Security:	Public	Date:	19 March 2019	File Ref:	ED1
Author/s:	Dario Stella				
Dept./Group:	Asset Strategy Gas				
Subject:	Comment on Elizabeth Drive Subdivision (SSD 8859) - Elizabeth Drive, Cecil Park

## GAS PIPELINE EASEMENTS

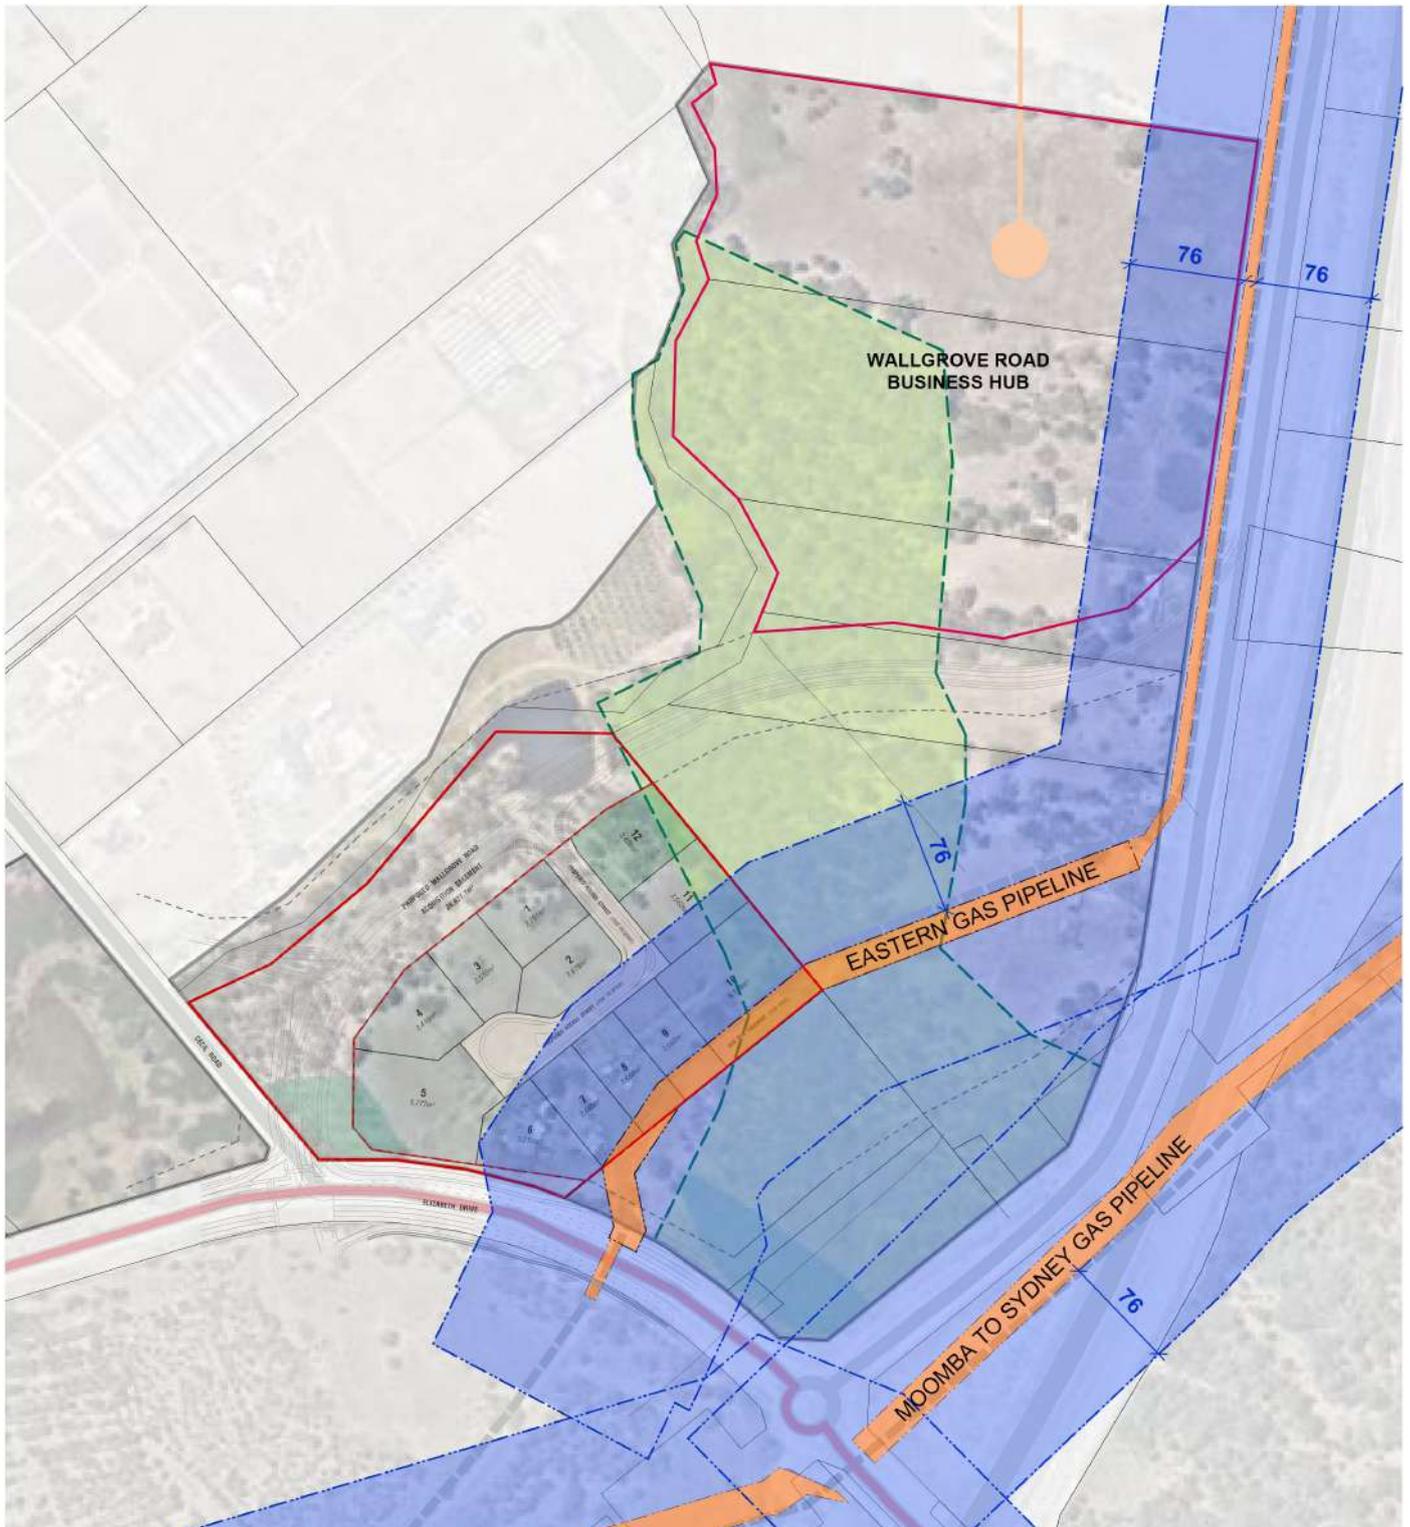
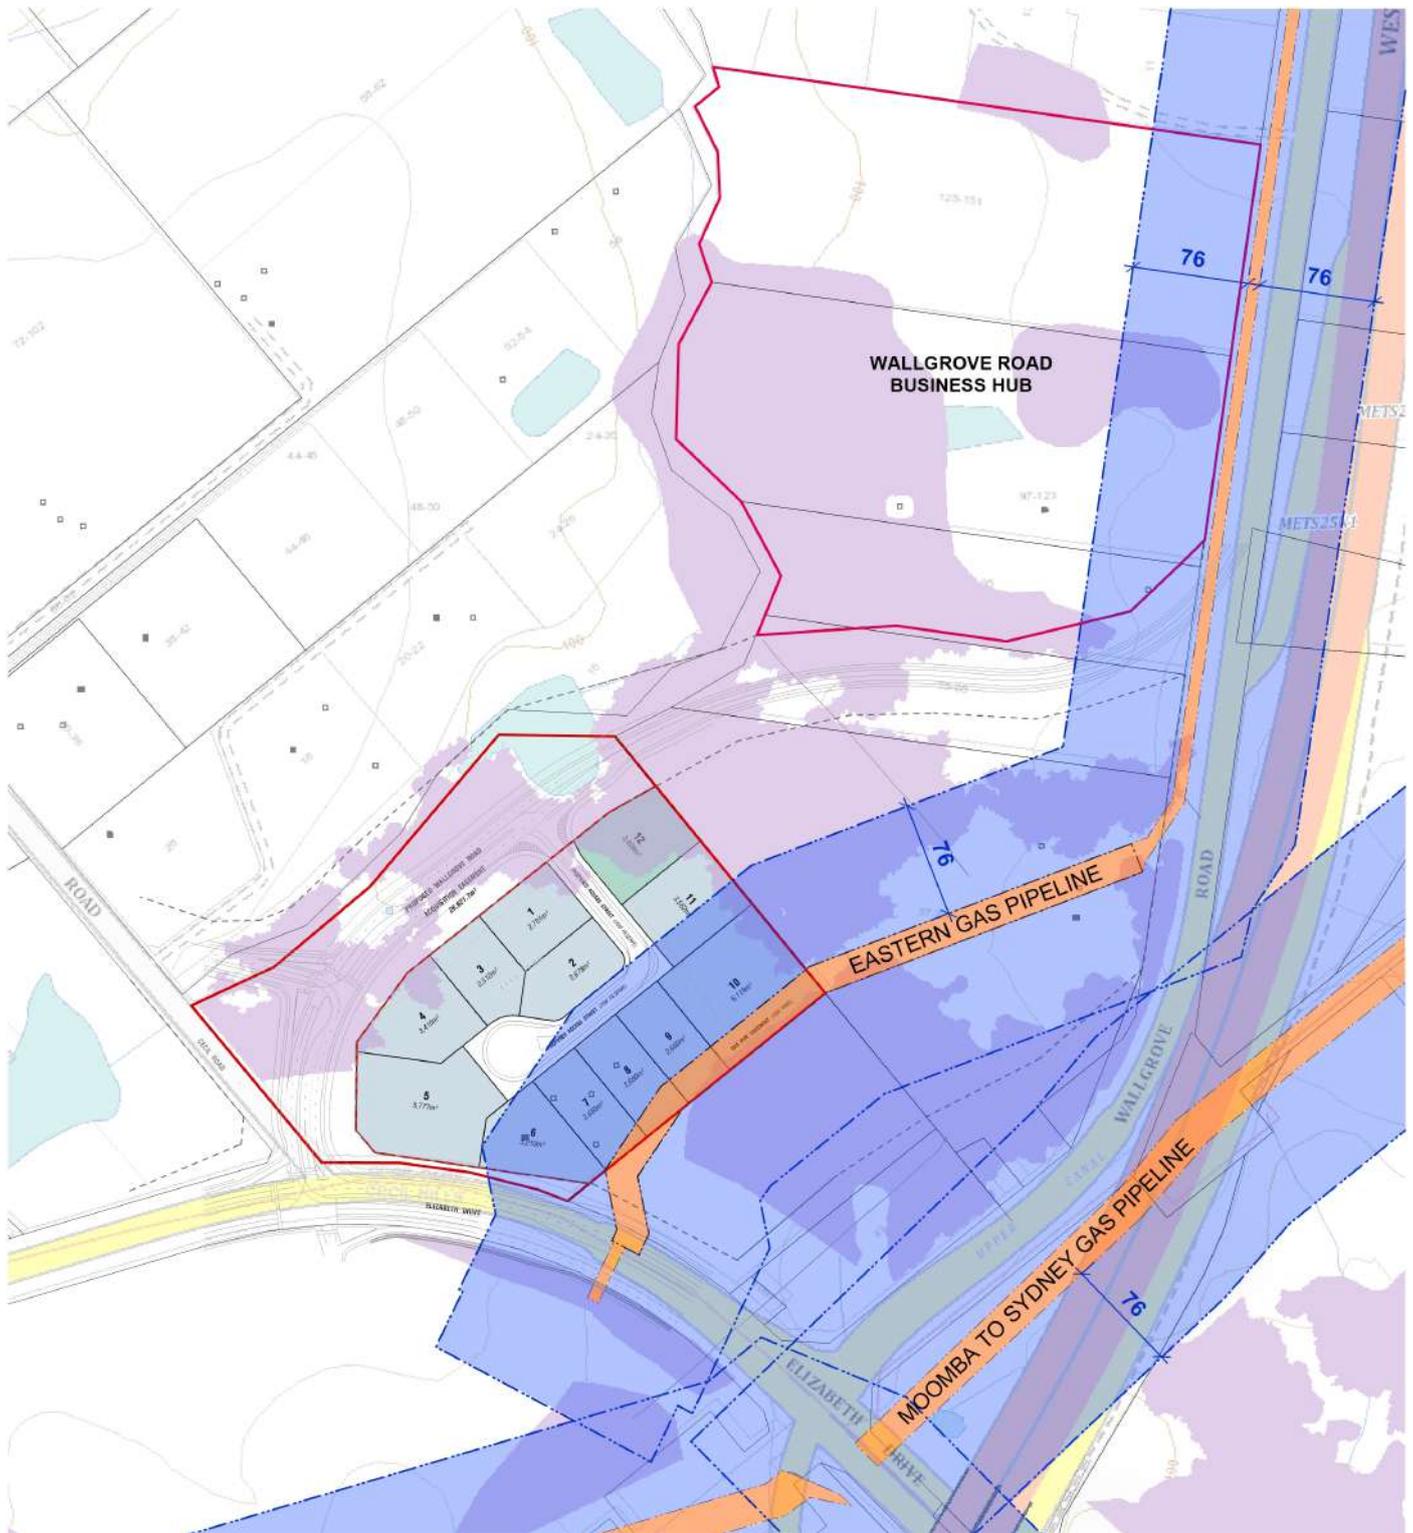
The proposed development will change the Location Class along the pipeline from R2 to T2. In addition the inclusion of *sensitive developments* within the measurement length of 766m will have the development considered as a High Consequence Area.

- 4.1.1 *Sensitive Developments* within 766m of Jemena's pipeline easement boundary must undergo a Safety Management Study for the purpose of identifying, considering and addressing the implications to the pipeline as well as to the community and environment.

- 4.1.2 Jemena strongly recommends the consenting authority do not approve *Sensitive Developments* within 76m of Jemena's pipeline easement boundary.
- 4.1.3 Should the consenting authority approve *sensitive developments* within 76m of Jemena's pipeline easement boundary, additional protection measures such as: pipeline relocation, protective concrete slabbing of pipeline would be required. All costs associated with the additional protection measures would be borne by development proponent/third party.

- 4.1.4 All development proposed (including roads, utilities, boundary fences) within Jemena's pipeline easement will require Jemena's review and acceptance.
